Appeal Decision

Appeal Ref: APP/R5510/D/22/3302033

27 Furzeham Road, Hillingdon, West Drayton UB7 9DD

- The appeal is made under section 78 of the Town and Country Planning Act 1990 against a refusal to grant planning permission.
 - The appeal is made by Mr Muhammed Salim Miah against the decision of the Council of the London Borough of Hillingdon.
 - The application Ref 71589/APP/2022/475, dated 15 February 2022, was refused by notice dated 25 April 2022.
 - The development proposed is erection of single-storey rear and side extension.
-

DWG TITLE
ROOF PLANS

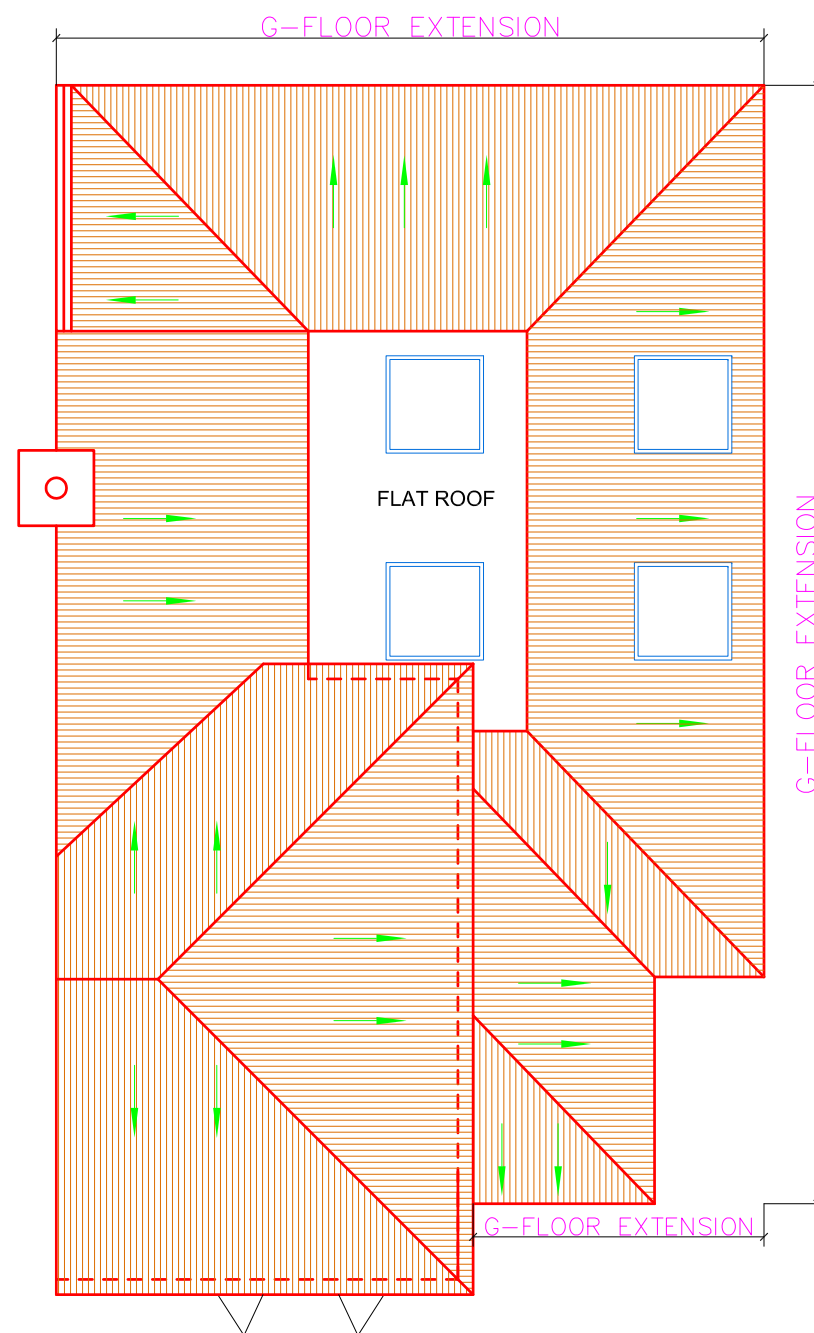
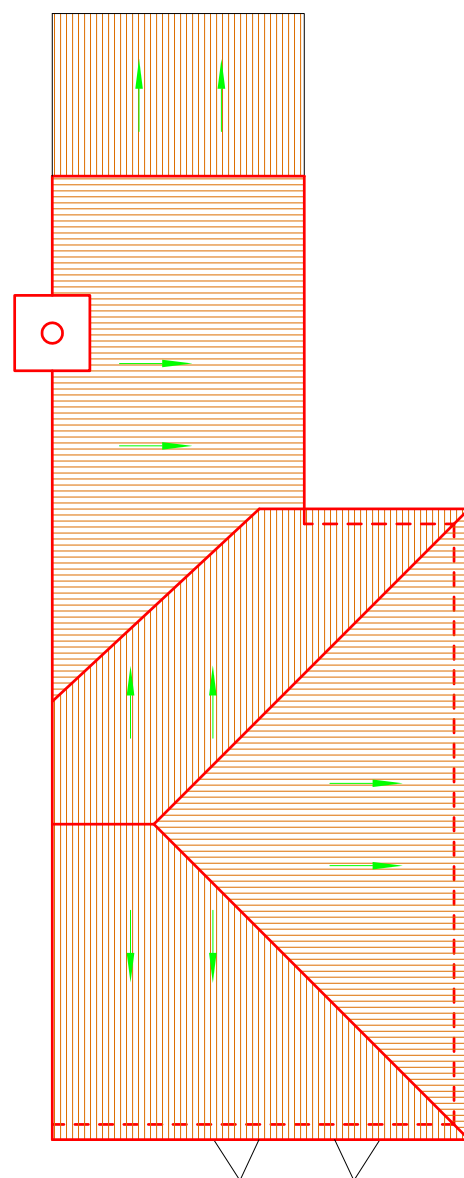
5. Furthermore, the form of the extension would result in an awkward roof arrangement with different roof forms and shallow pitches that would not match the main building. Nor would the size and design of the window in its front elevation suitably reflect the window composition and hierarchy of the main front elevation. Overall, the proposal is not a well-designed and sympathetic addition to the host property.
